Your ref: SSD 9153  
File no: MC-18-00002

**Project: SSD ASICS Warehouse and Distribution Centre**  
**4 Darling Street, Marsden Park**  
**Re: Blacktown City Council comments**

## ATTACHMENT A

LANDSCAPE SITE PLAN
SCALE - 1:500

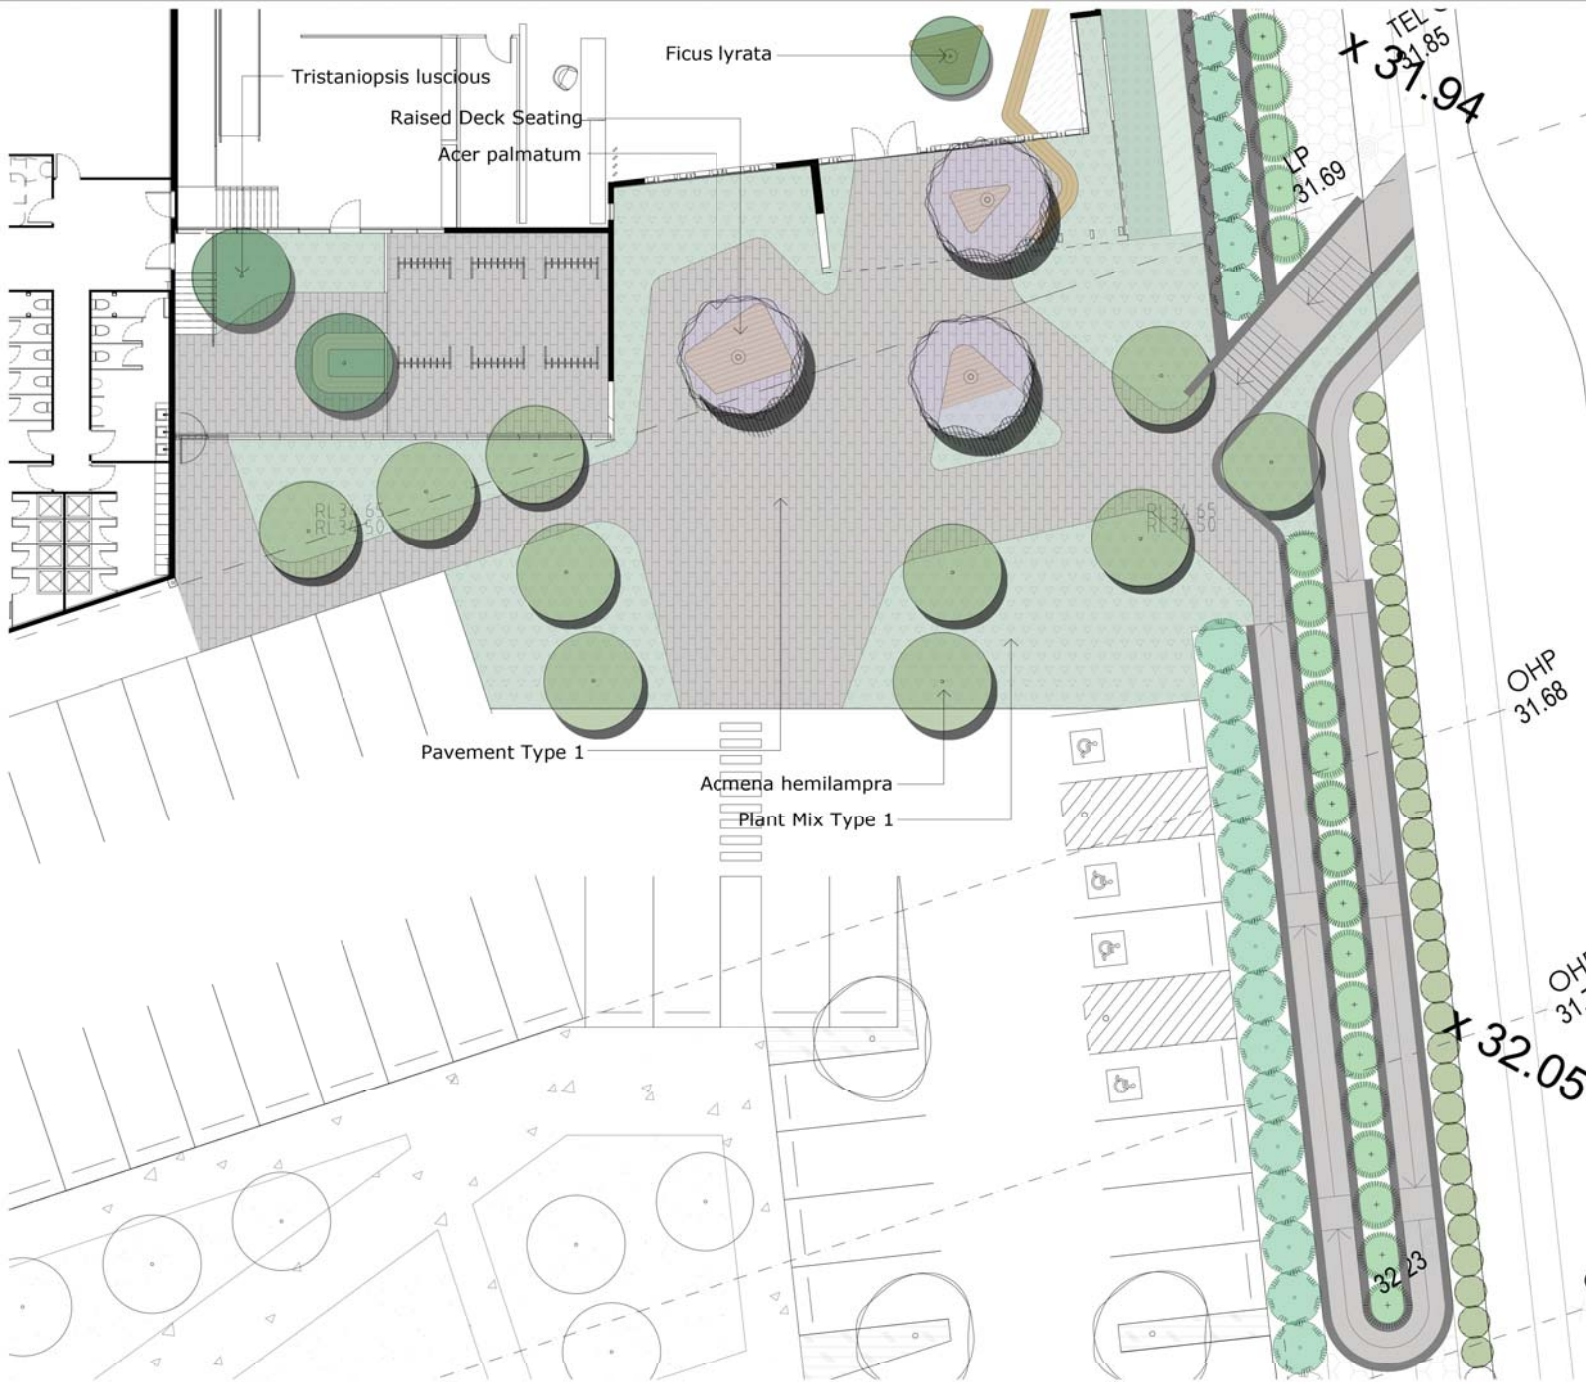
The proposed landscape plans indicate street trees are to be provided along part of the southern boundary only. It is recommended that street trees are provided for the full length of the street frontages (with the exception of the areas affected by the transmission easement) to assist with improving the streetscape and providing opportunities for shading.

Drawing		SITE PLAN	
Drawing Number		118101_A100	
Issue		N

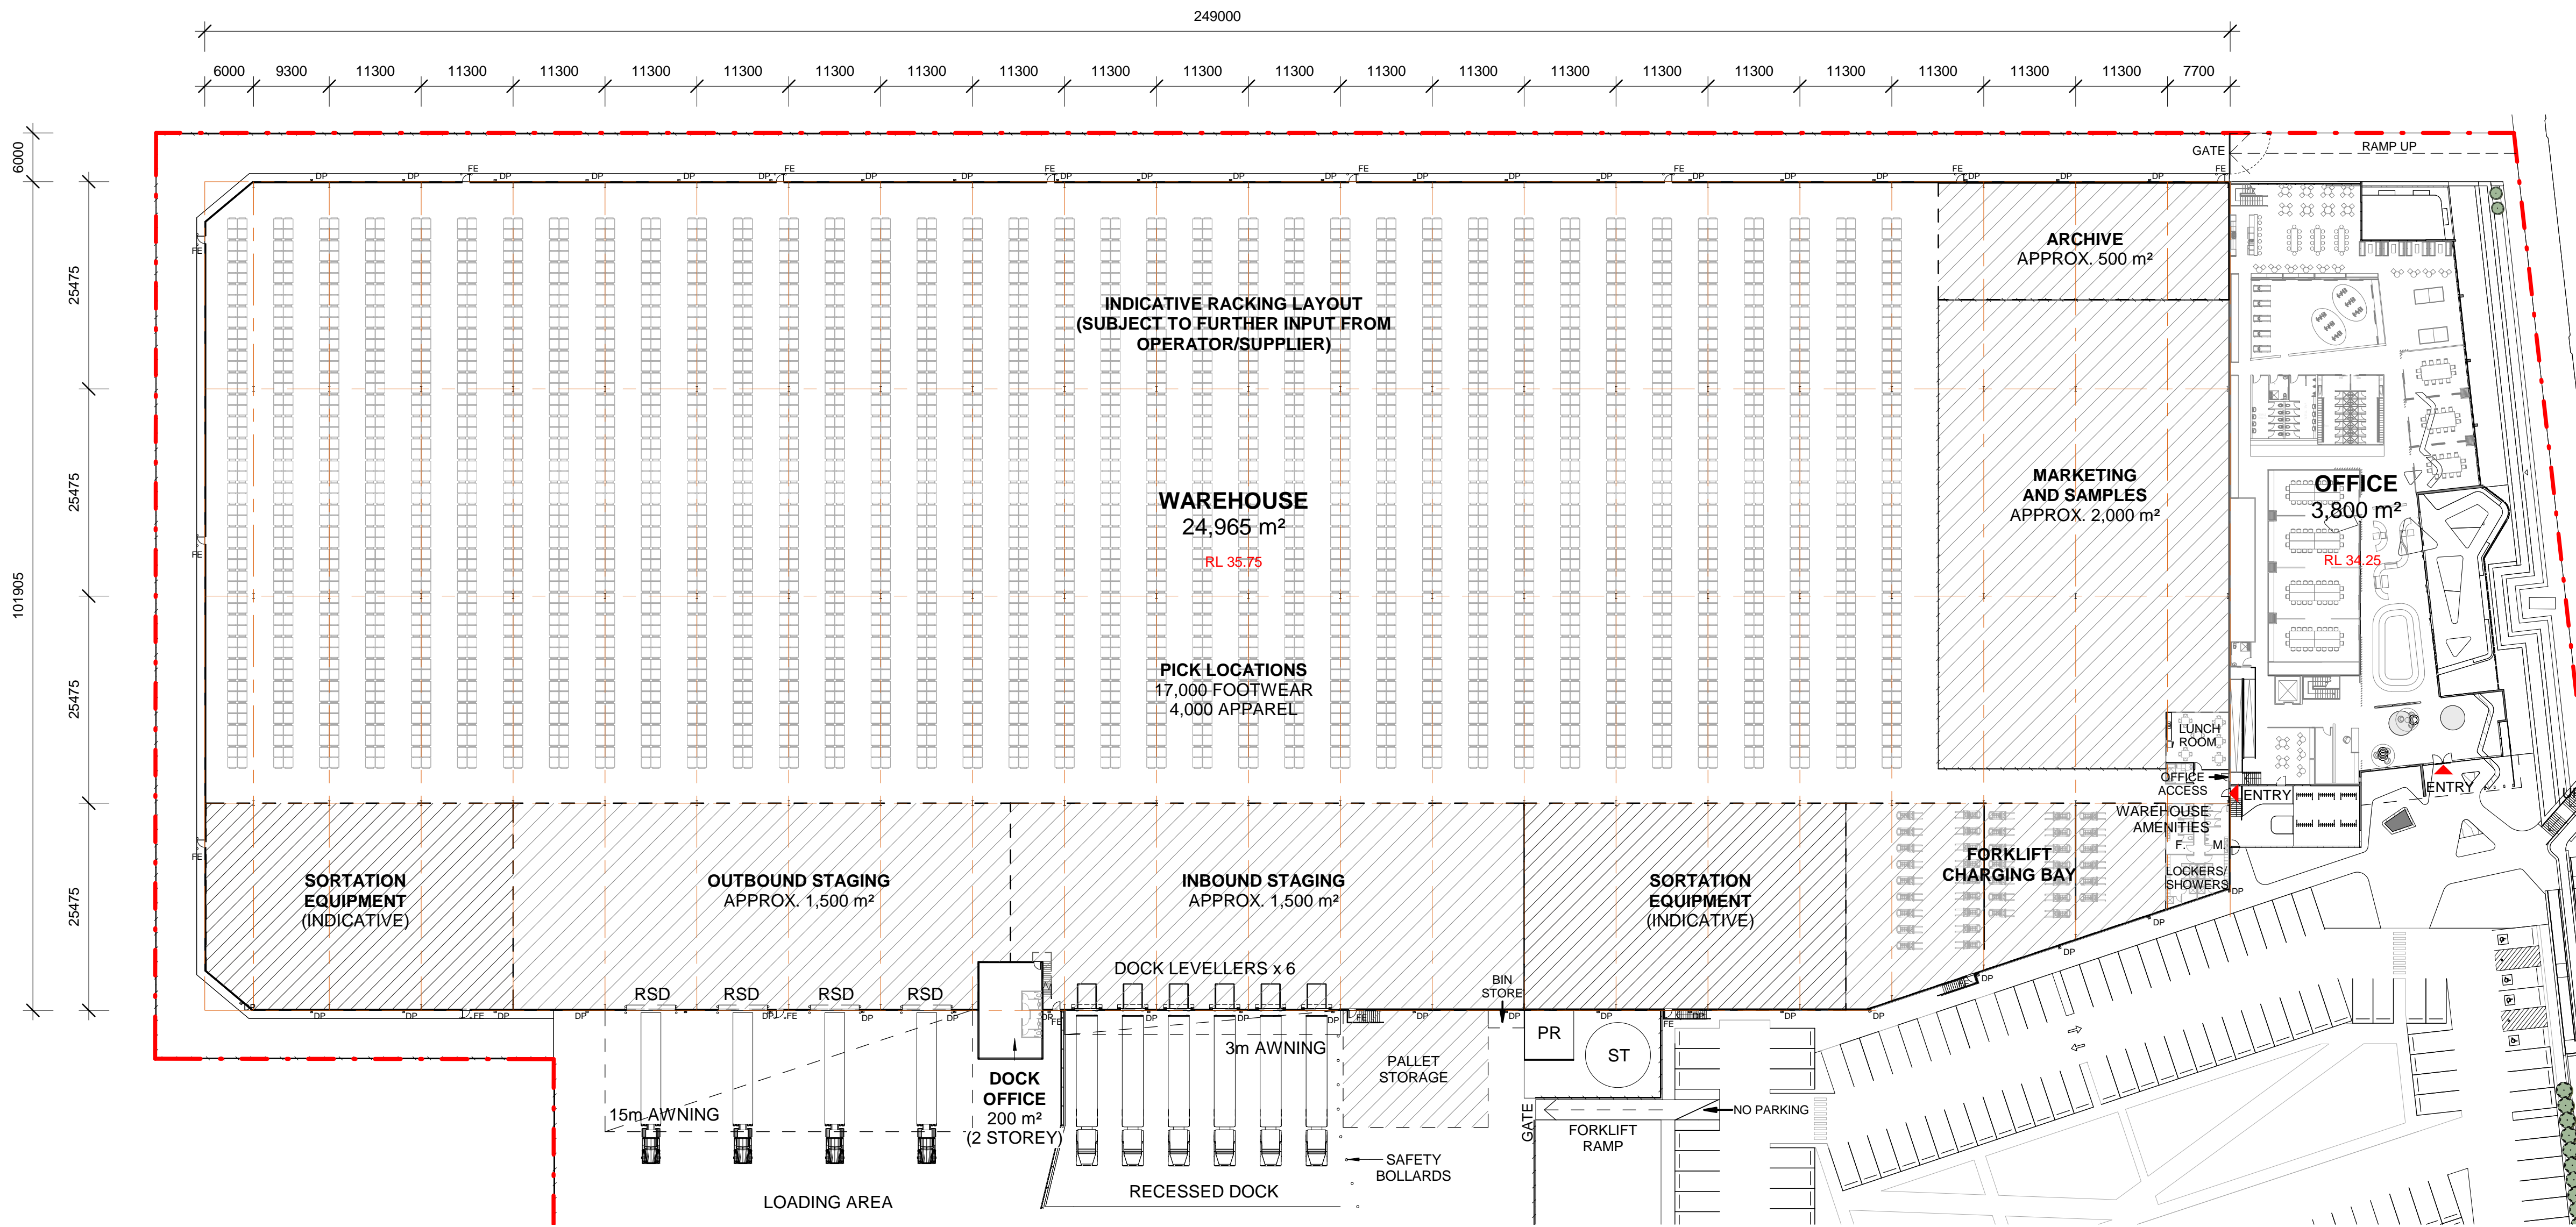
- Additional landscaped zones to the perimeter of the site to provide further soft screening of the development and to further reduce urban heat island effects
- Minimum 2 metre wide landscaped zone to both sides of the truck entry driveway
- Allow for permeable pavement to the car parking area (WSUD initiatives)
- Building signage on the retail showroom appears excessive. The design may benefit from a more simplified strategy which reduces the number of signs and allows the 'Architecture' (finishes) to be a feature that is intended.

The Traffic Report indicates 321 parking spaces are required based on the Blacktown City Council Growth Centre Precinct Development Control Plan 2018 controls for this site. However, due to the nature of the proposed facility 243 car parking spaces are provided. Whilst the proposed staffing level may not require more than 243 parking spaces, it is necessary for the compliant number of car parking spaces to be capable of being provided on the site to cater for the long term needs of the site and the Precinct, such as additional staff or a new tenant that generates a higher parking demand. The Applicant is required to submit a concept plan which demonstrates potential car parking spaces on the site to comply with the requirements of the Development Control Plan.

1 SECTION 1
1 : 500

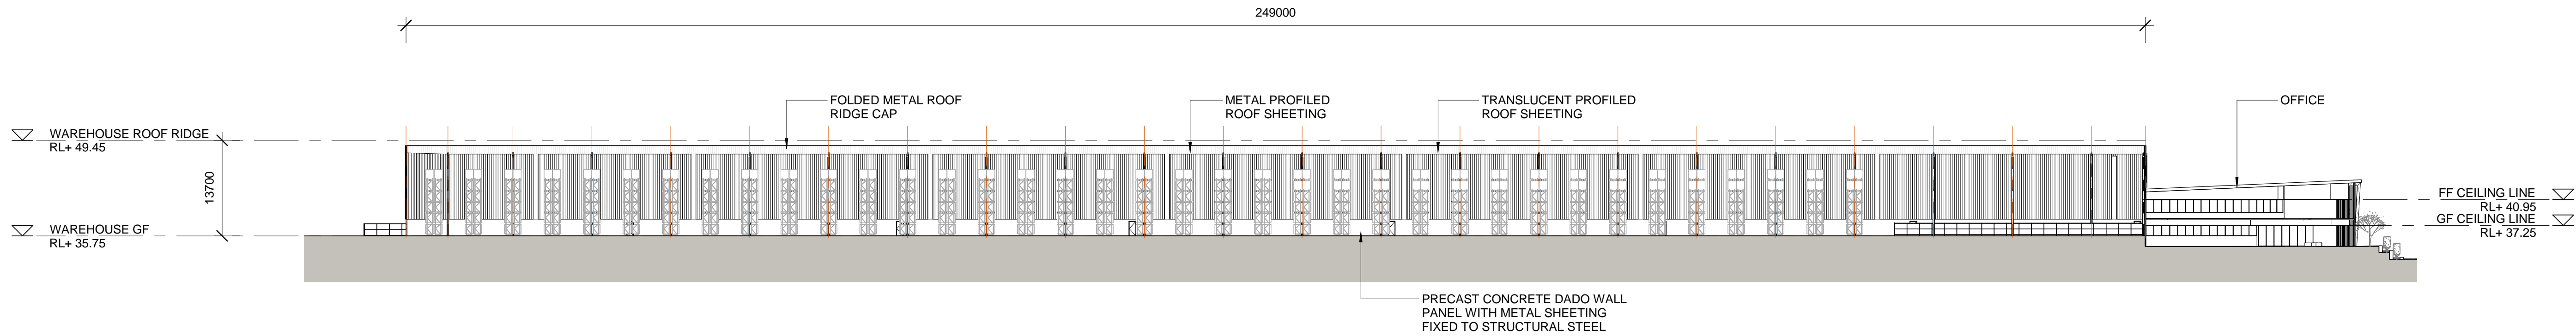
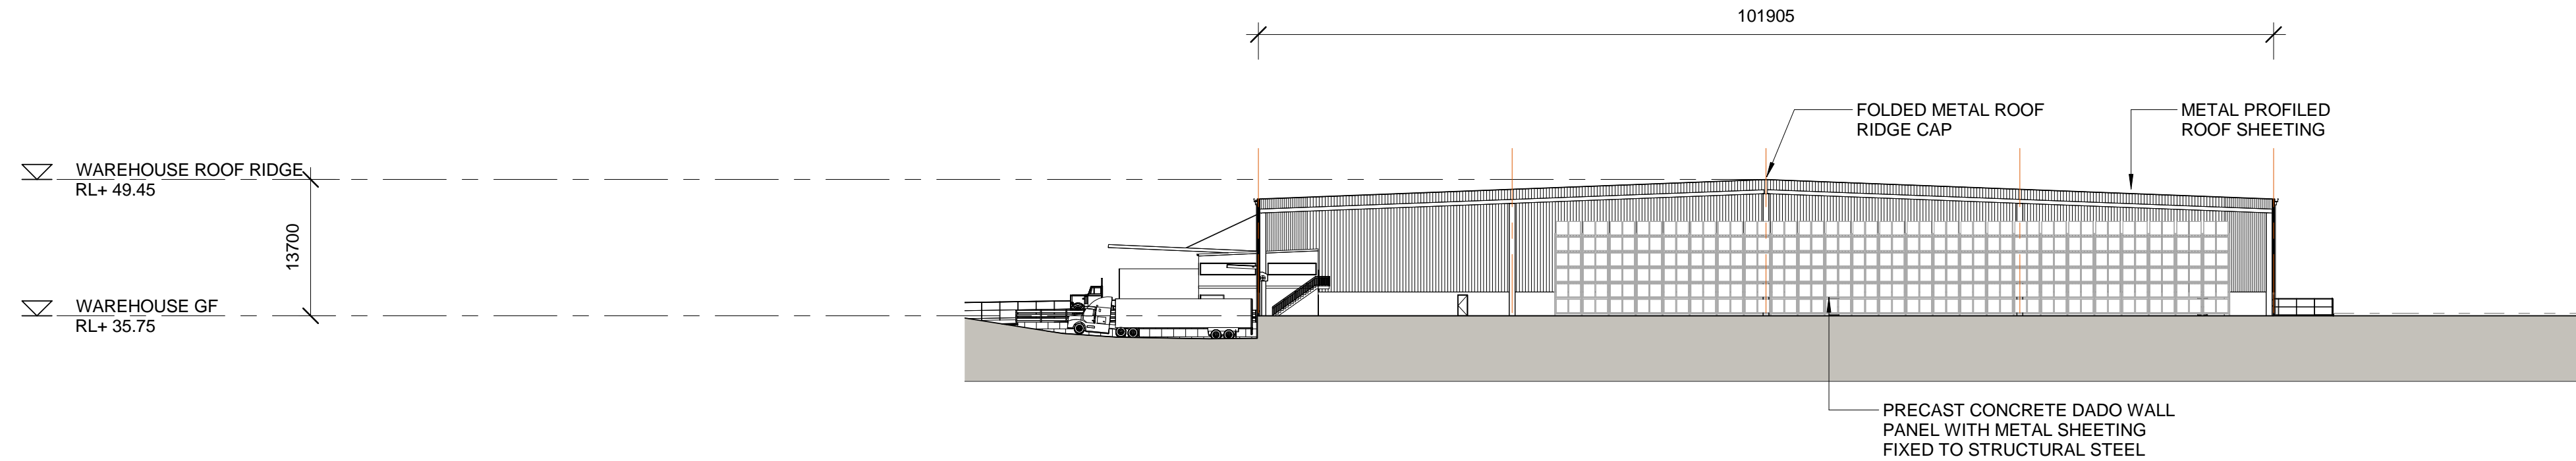
The proposal indicates that cut up to 2.7 metres is proposed at the north-west corner of the site with a soldier pile wall on the new boundary. The Applicant is required to provide cross sections in this location which demonstrate the anticipated levels of the adjoining lots, including consideration of the likely finished levels to achieve suitable benching for development, fencing, and how level differences will be managed (for example, will the adjoining lots include tiered retaining walls within their boundaries).
